SCOPING OPINION:

Proposed Lostrigg Solar

Case Reference: EN0110004

30 July 2024

Legend

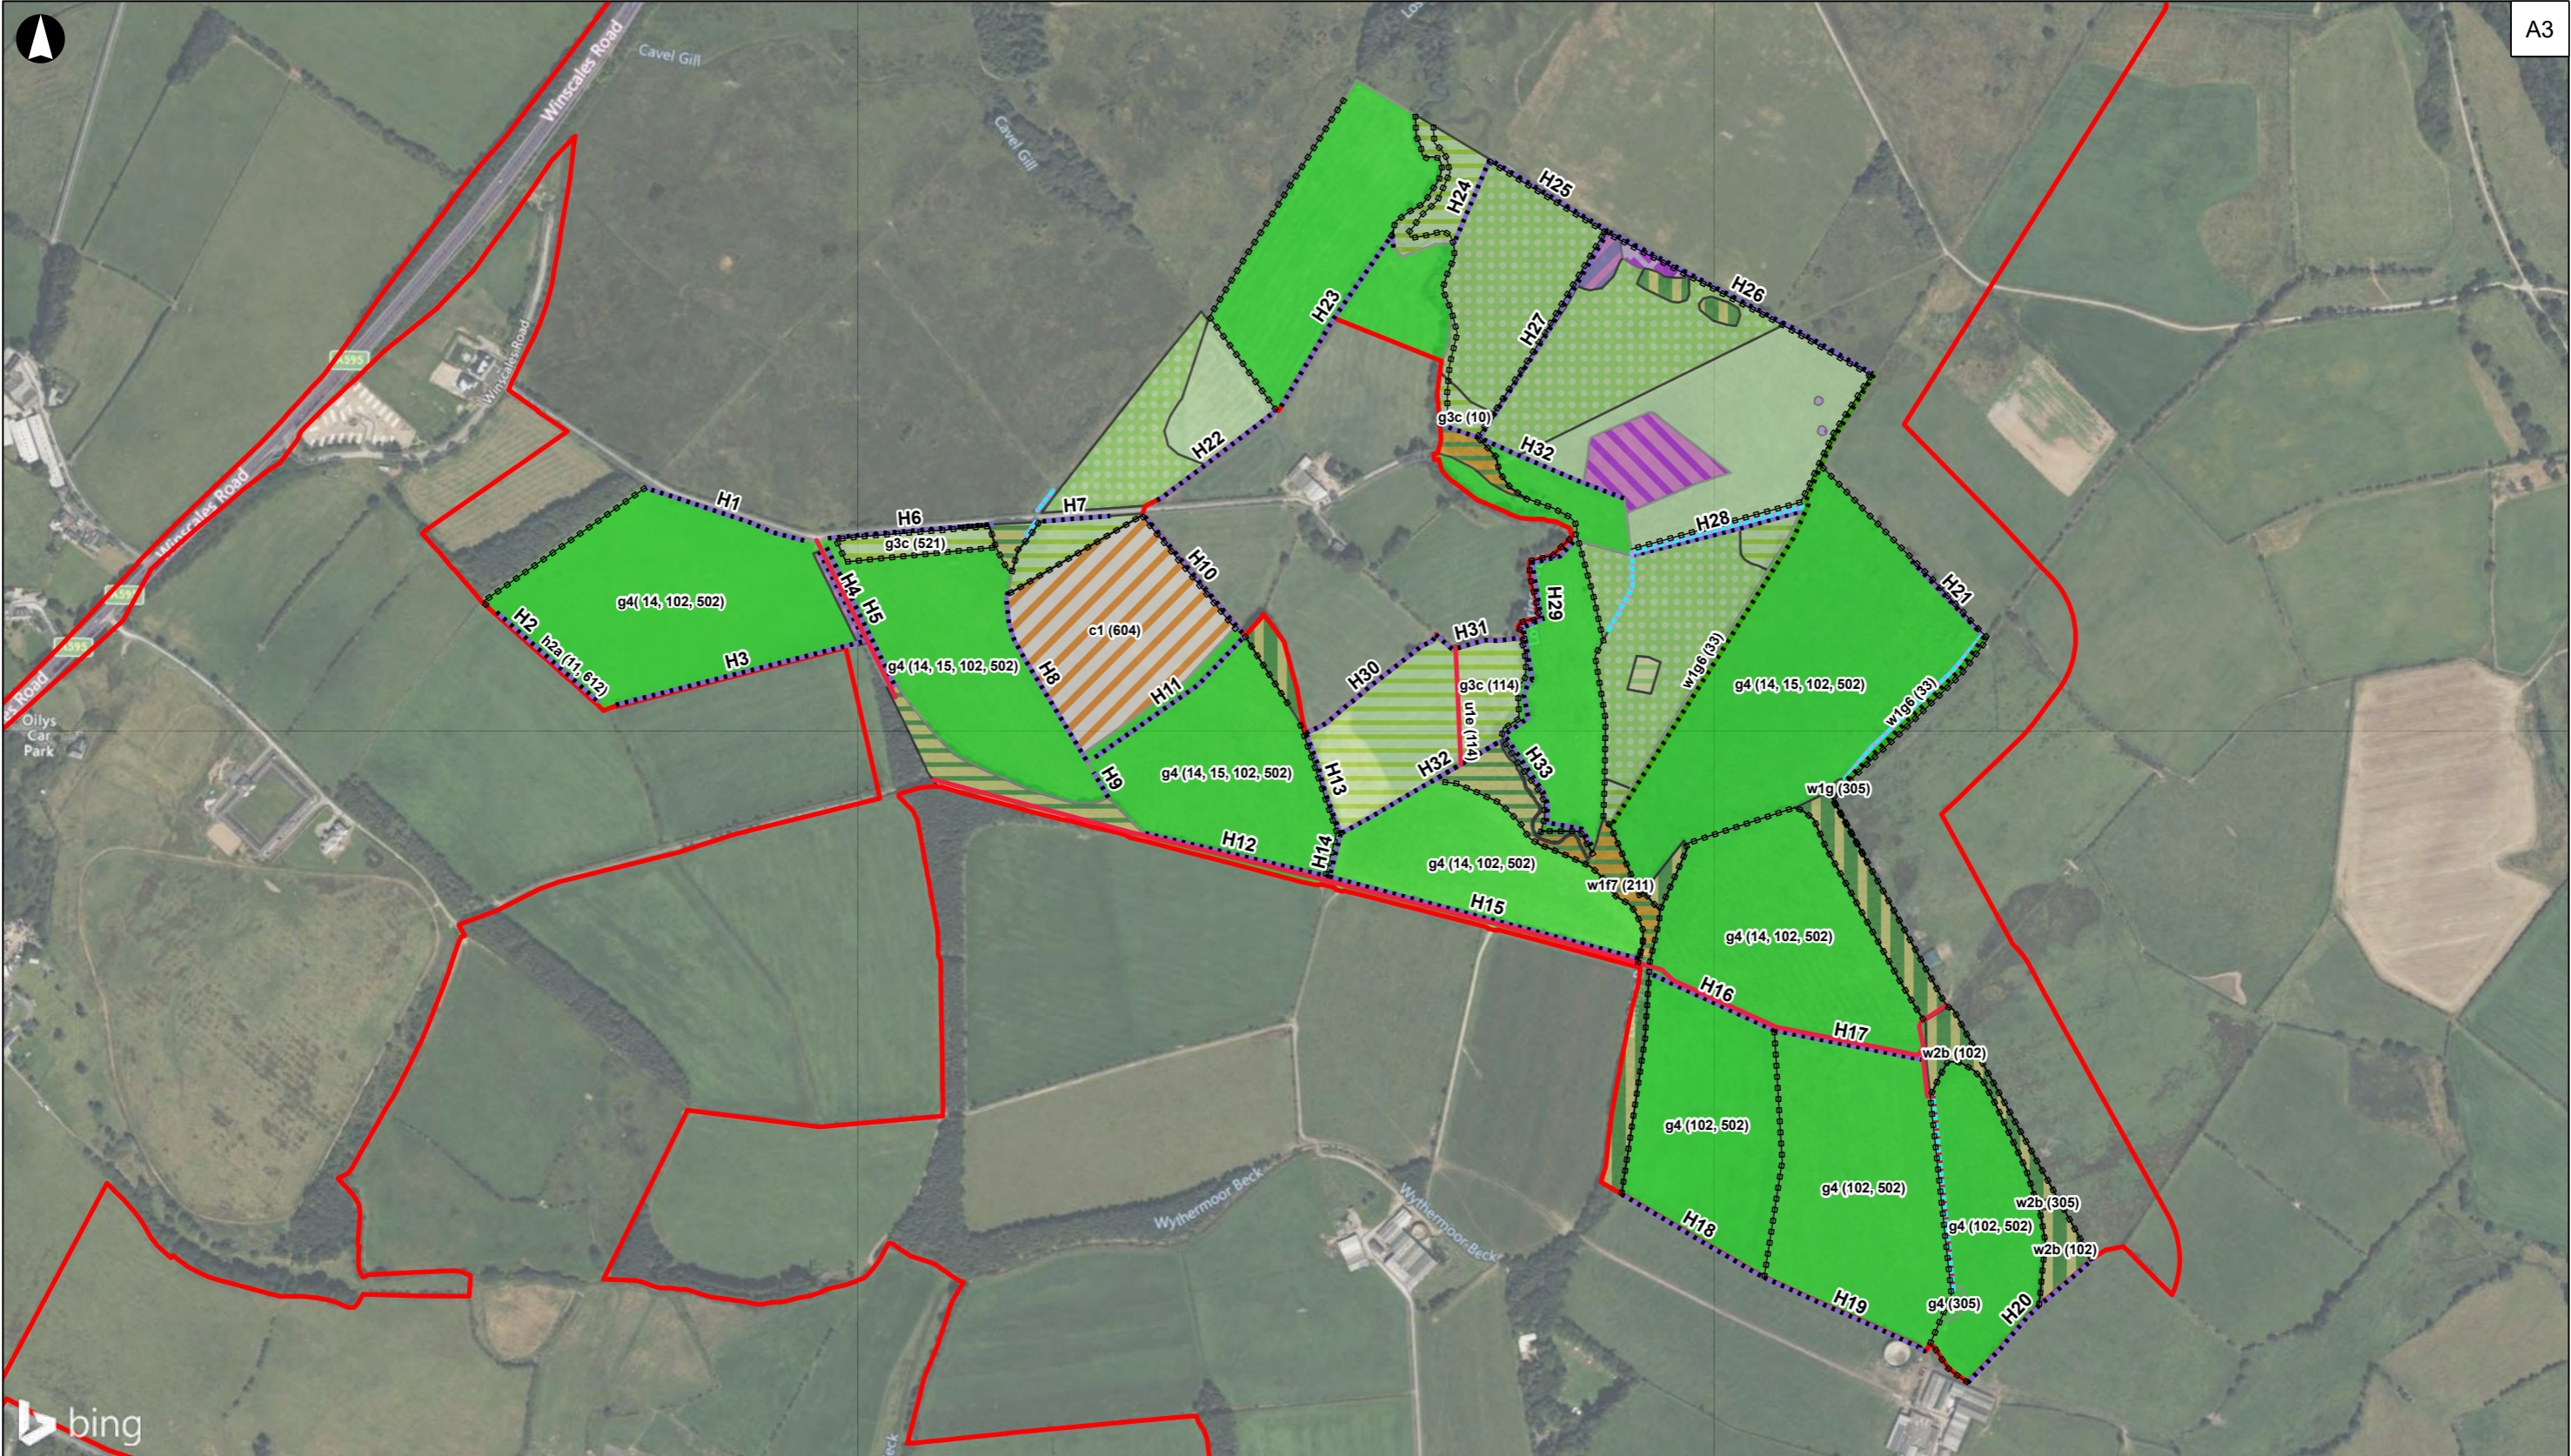
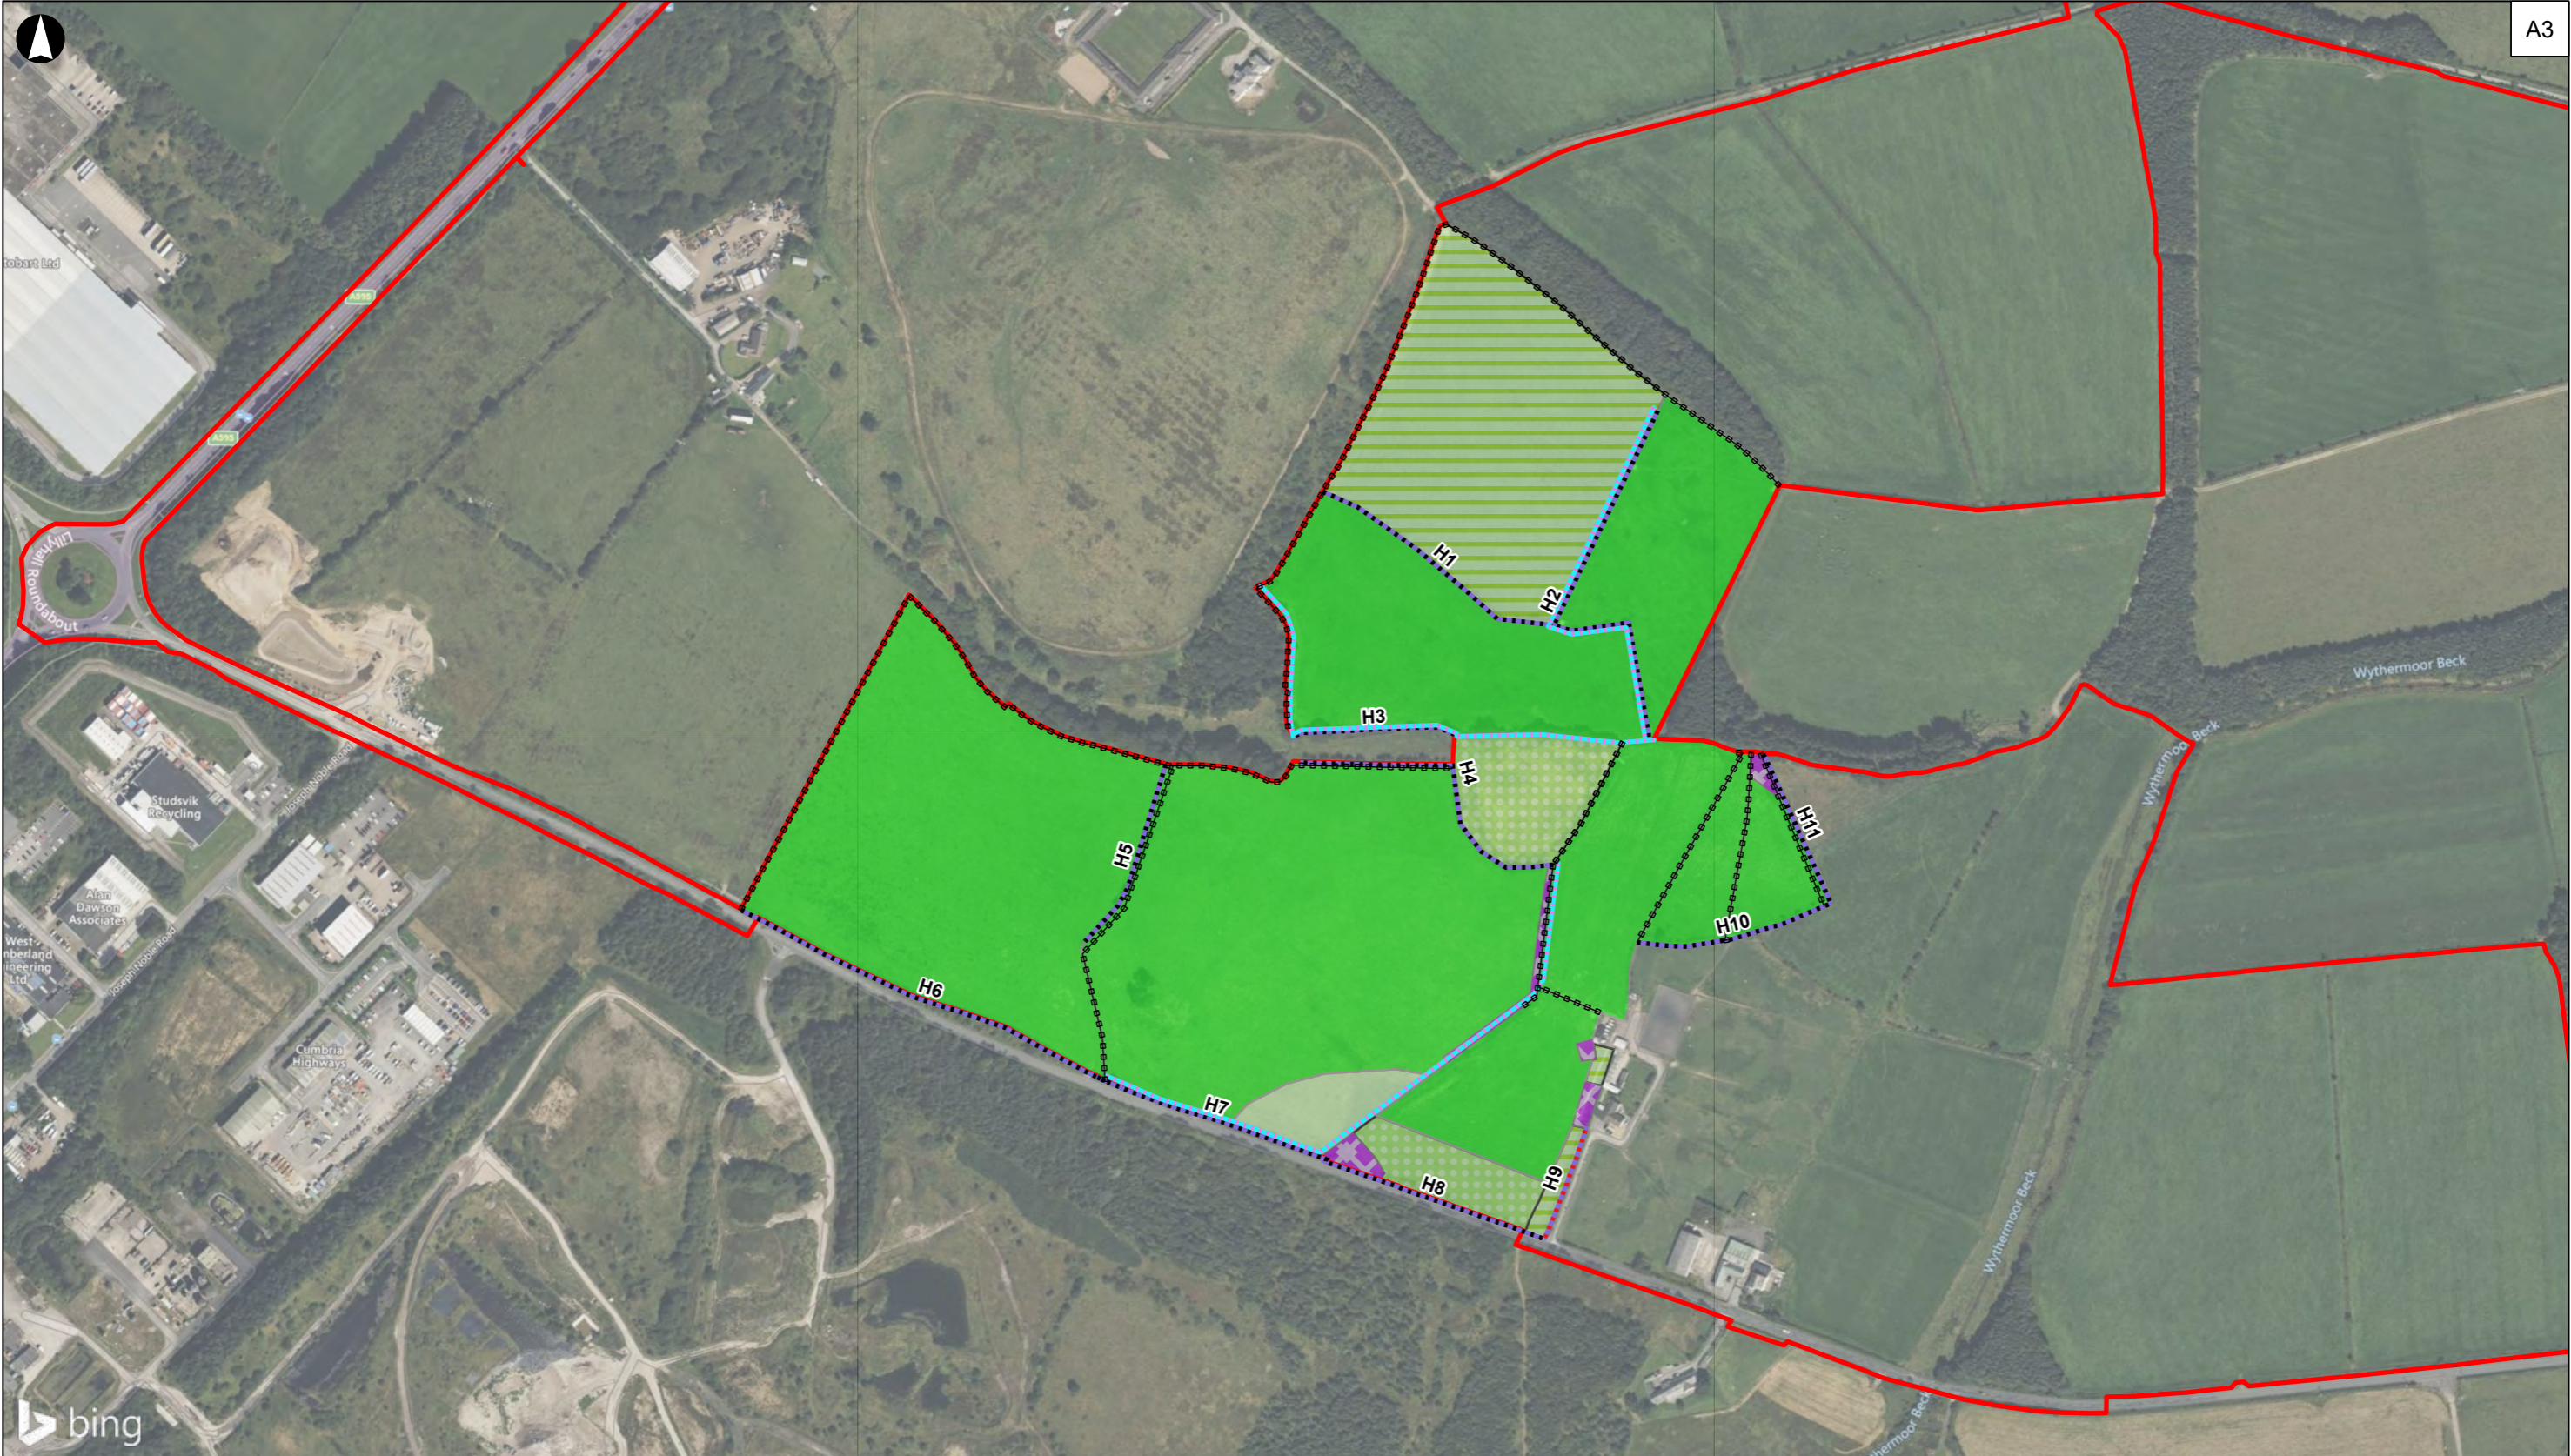
ID	Ref	Applicant’s proposed matters to scope out	Inspectorate’s comments
331	Paragraph 7.8.2.5 and Table 7-7	Effects on priority habitats during operation	Scoping Report Figure 7.4.1 to Figure 7.4.5 identify areas of priority habitat and show this as ‘h2a hedgerow’. The Scoping Report refers to purple moor grass and rush pasture as Priority Habitat (A35), yet these areas do not appear to be shown on the supporting figures. The Inspectorate does not, therefore agree to scope this matter out at this stage and considers that the ES should apply a consistent and accurate approach between the main report and figures and assess significant effects to these habitats where they are likely to occur.
332	Paragraph 7.8.2.5 and Table 7-7	Effects on the following species during operation: <ul style="list-style-type: none"> • Badger • Otter • Water vole • Amphibians • Reptiles • Fish • Invertebrates Protected and notable plants	These species are proposed to be scoped out on the basis that no direct effects are anticipated, and indirect effects can be managed by the use of embedded design measures and the outline Landscape and Environmental Management Plan (oLEMP). The Inspectorate agrees that significant effects are unlikely to occur during operation and these may be scoped out for this phase.

338	Paragraph 7.8.1.3 and Figure 7.4.1 to 7.4.5	Priority Habitats	The Scoping Report acknowledges that the Proposed Development may affect areas of Priority Habitat which are present on site. These areas do not appear to be shown on the supporting figures. The ES should provide a plan which shows the location of all areas of priority habitat which may be affected by the Proposed Development. In their response, the Environment Agency have commented that other types of priority habitats are located in the area such as upland flushes, fens and swamps. The ES should include all areas of Priority Habitat on relevant figures.
339	Table 7-4	River Derwent and Bassenthwaite Lake Special Protection Area, Solway Firth SAC and River Ehen SAC.	It is noted that Table 7-4 does not include all qualifying species which are included in the site designations. The ES should ensure that all qualifying features for all designated sites are included. The Applicant should take note of comments provided by the Environment Agency, in their response to the Scoping Report.
